From: [Brian Brunner](#)
To: [Jeremiah Cromie](#)
Cc: [Laura Osiadacz](#); [Barb Brunner](#)
Subject: Casto SE-22-00054 SEPA Comments
Date: Monday, June 13, 2022 11:53:56 AM

**BOUNDARY AND TOPOGRAPHIC SURVEY**

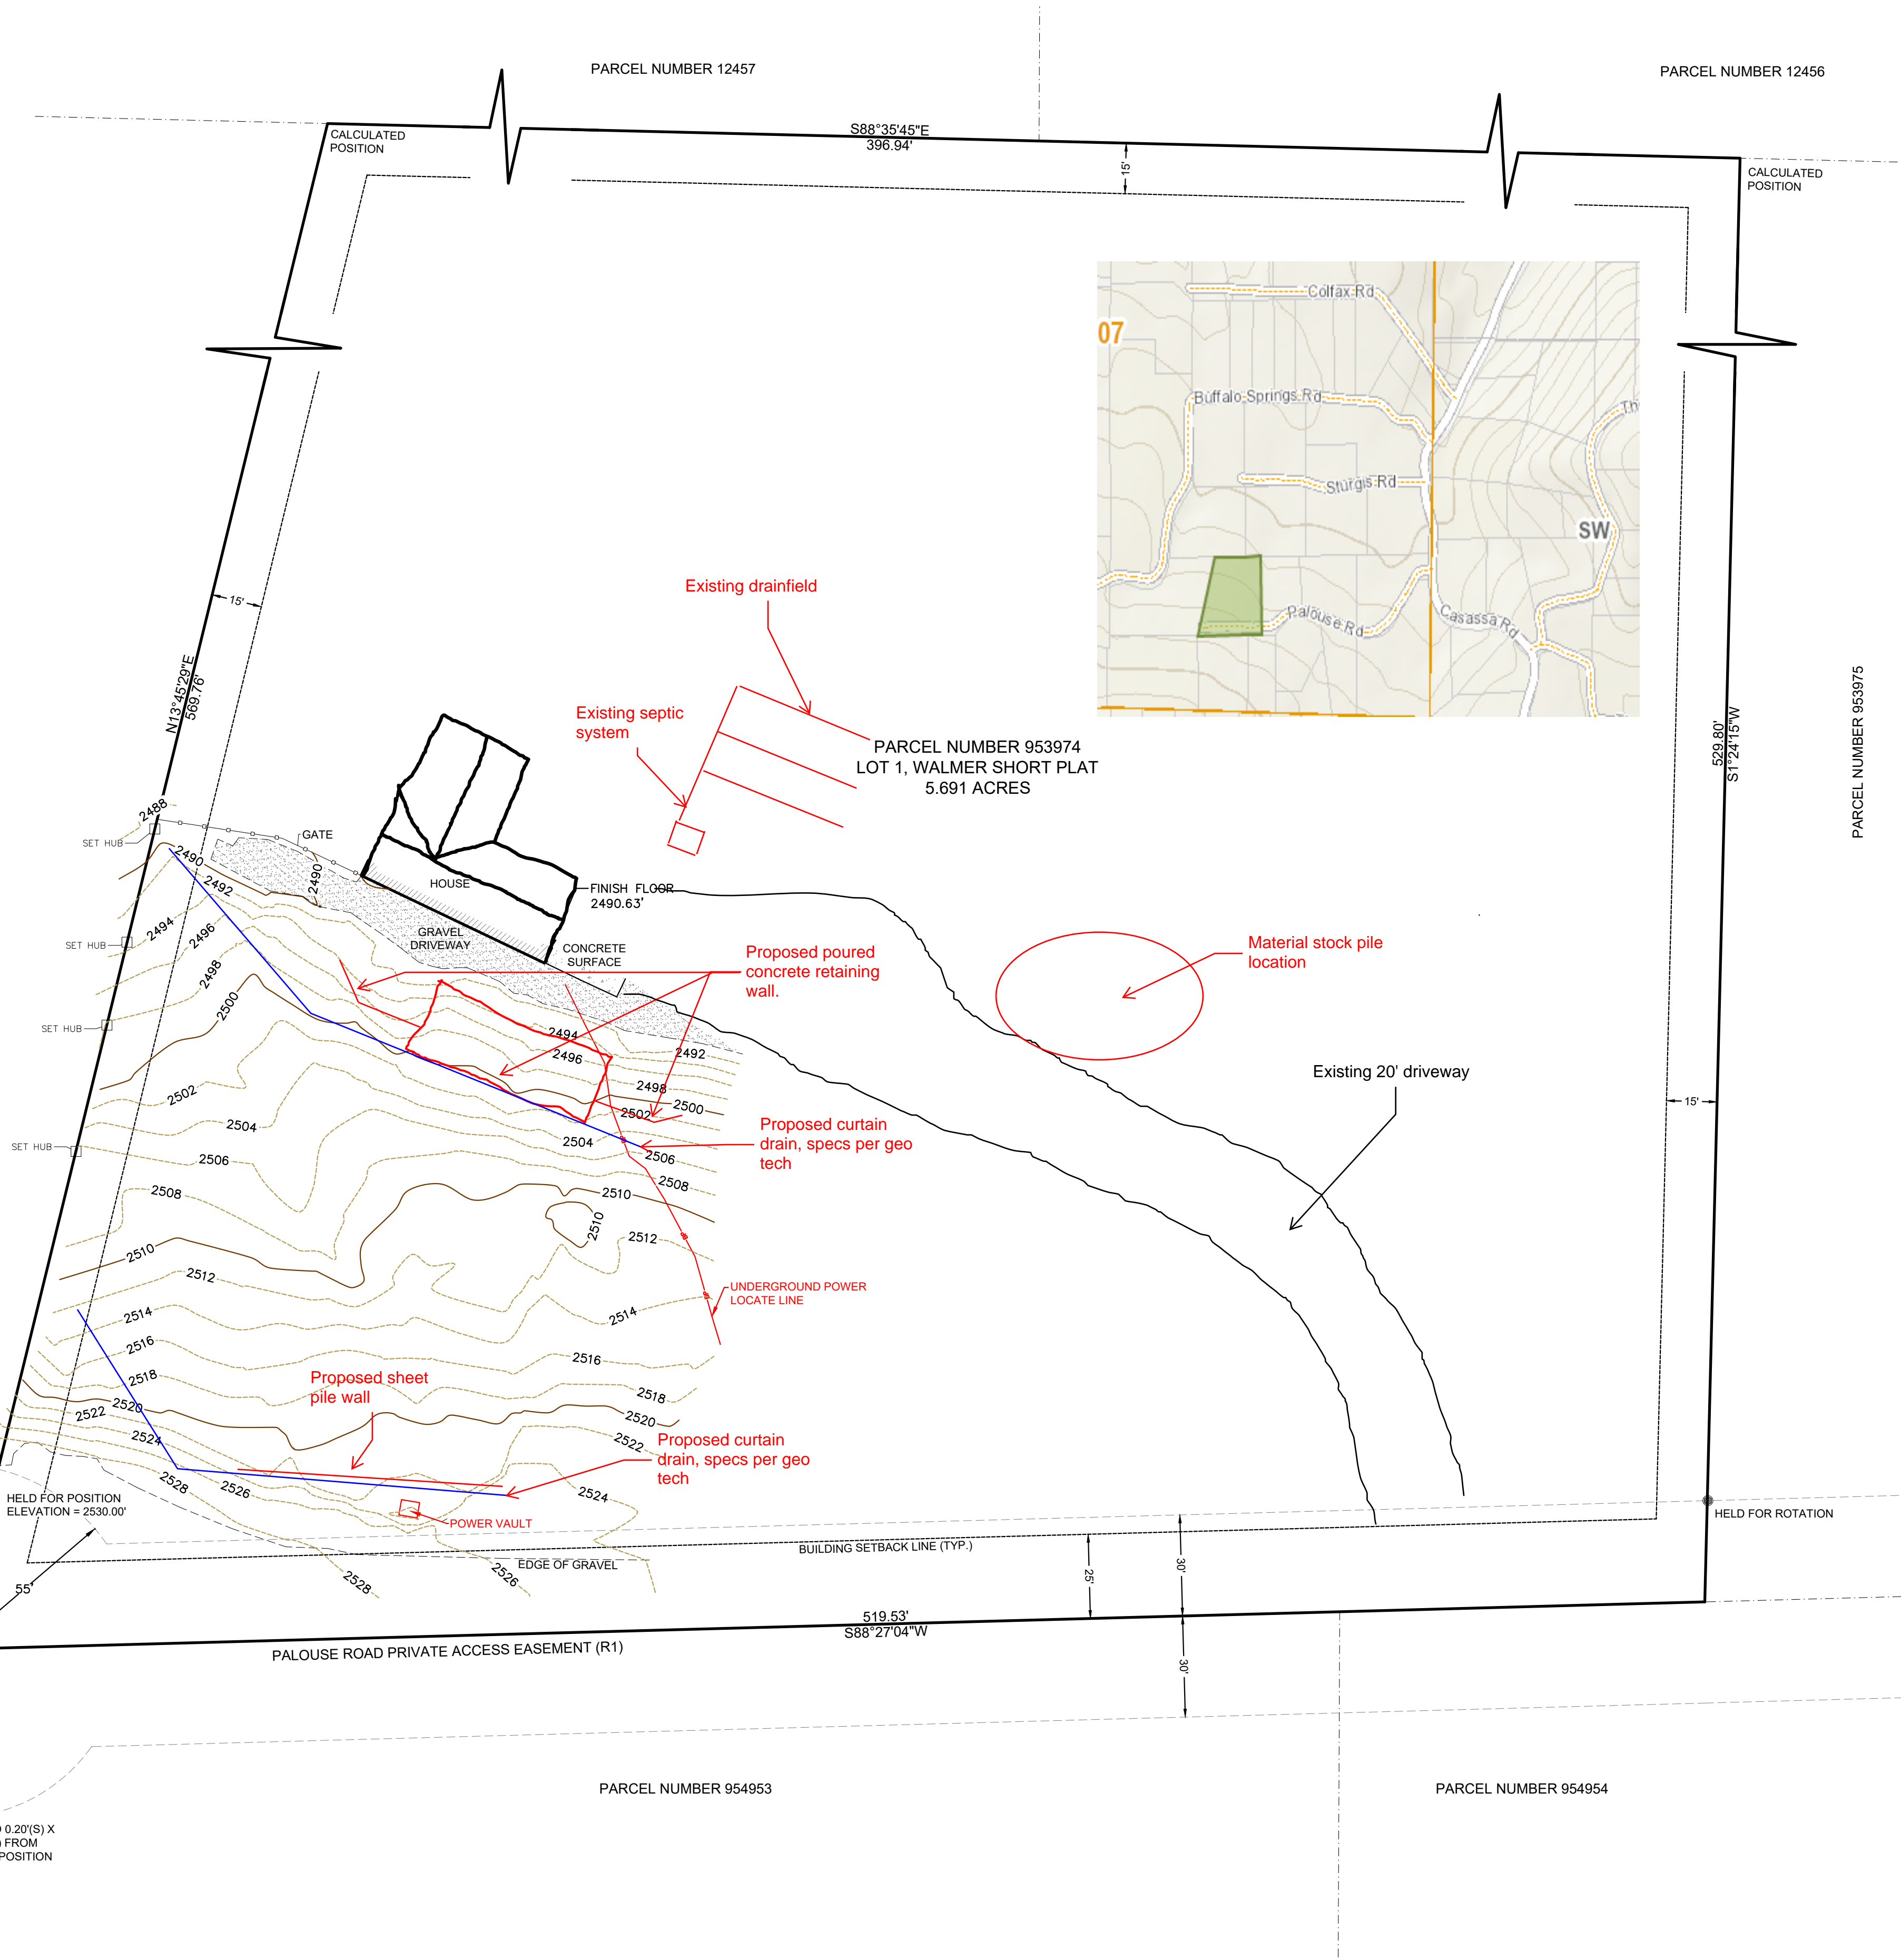
I didn't see any info on the grading plan to restore Palouse Rd to county standards. This should be the FIRST and most important task to be completed as expeditiously as possible. CDS noted in their code violation that "your actions have interrupted the legal access of neighbors and the road must be reconstructed immediately to prevent further collapse and stop the slide that is still occurring."

Sheet Number
S2.0
2 of 2

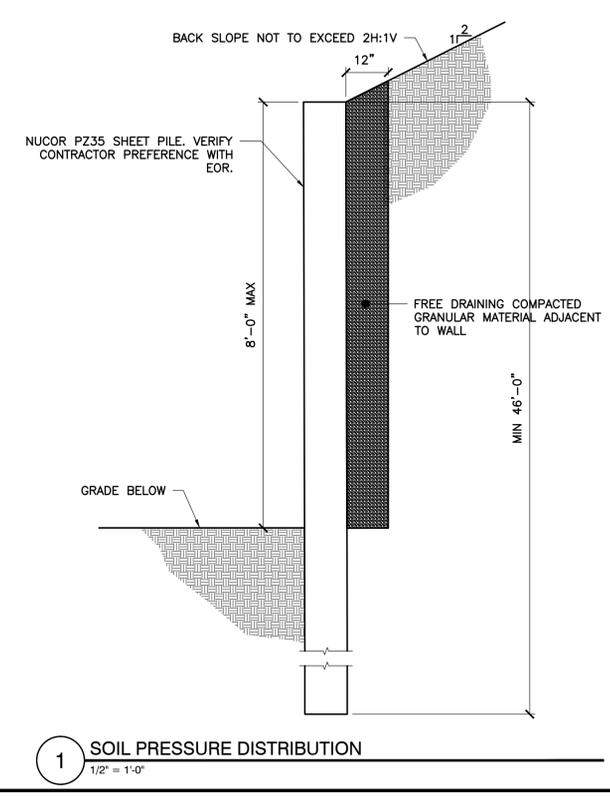
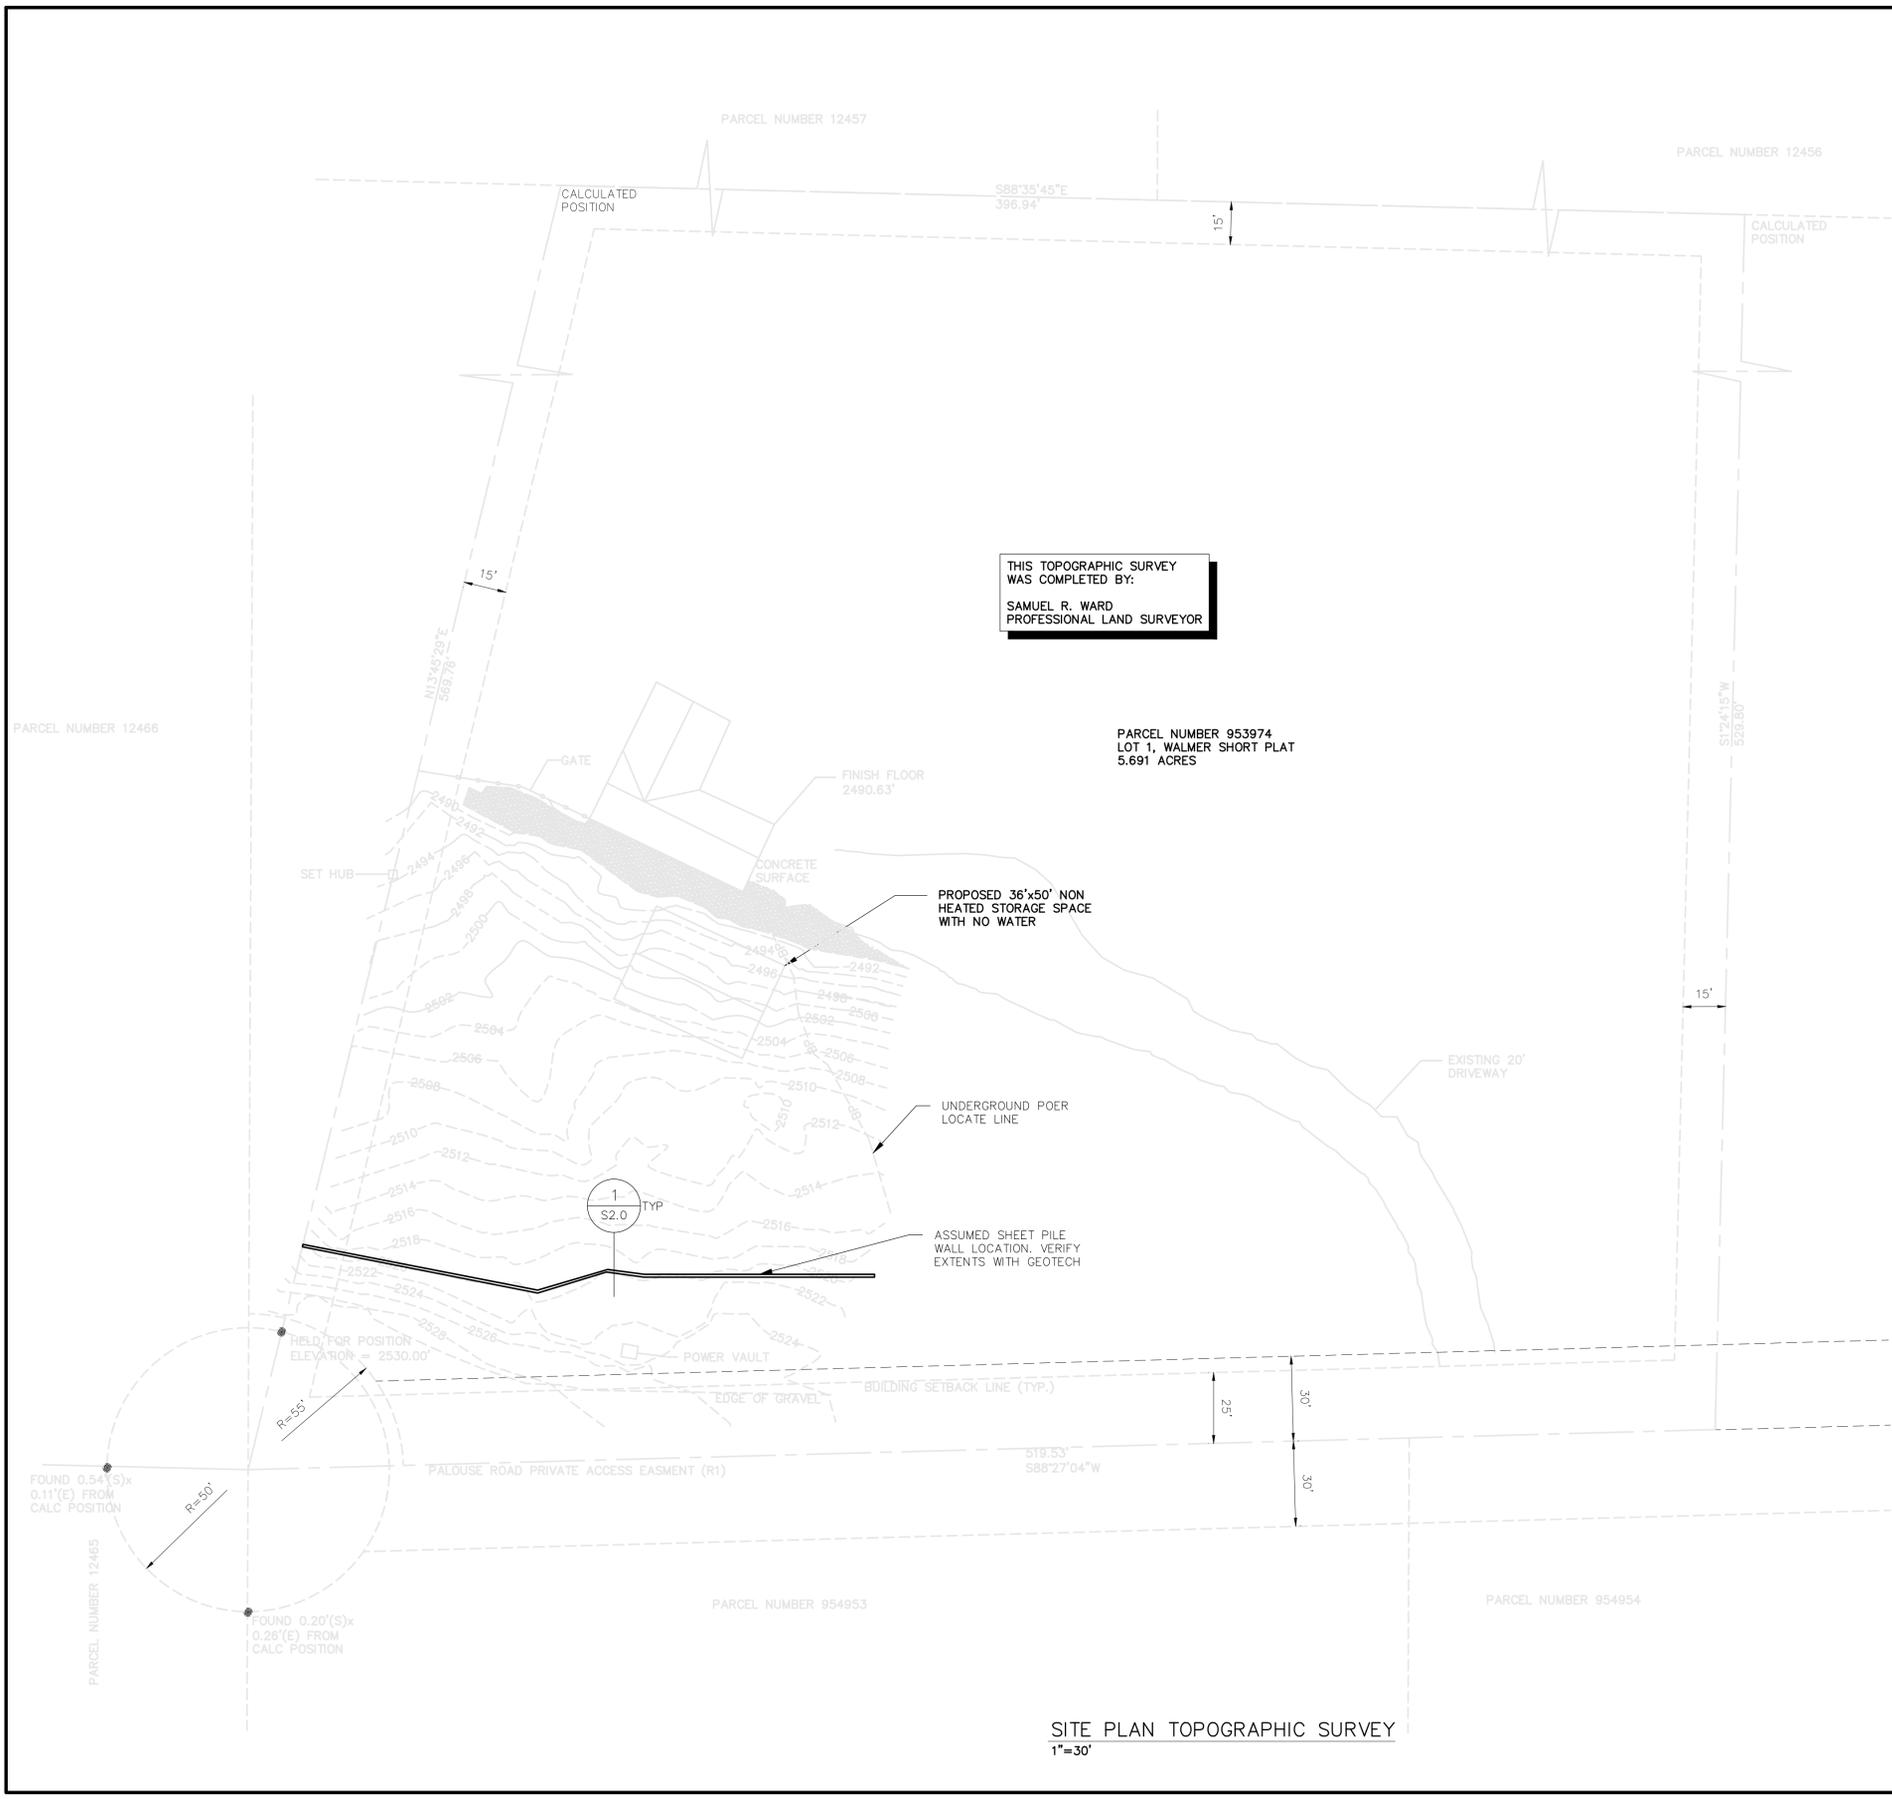
I had an excavation company for 17 years and moved a lot of dirt and worked on a couple sites on the west side with sheet pile walls operating an excavator and hoe pack for the contractor. I have never heard of a "temporary sheet pile wall, and no analysis and design of bracing, temporary or permanent, requested or conducted. All bracing, temporary and permanent, shall be the responsibility of contractor." Who is the contractor and are they certified/licensed to do this type of work ???
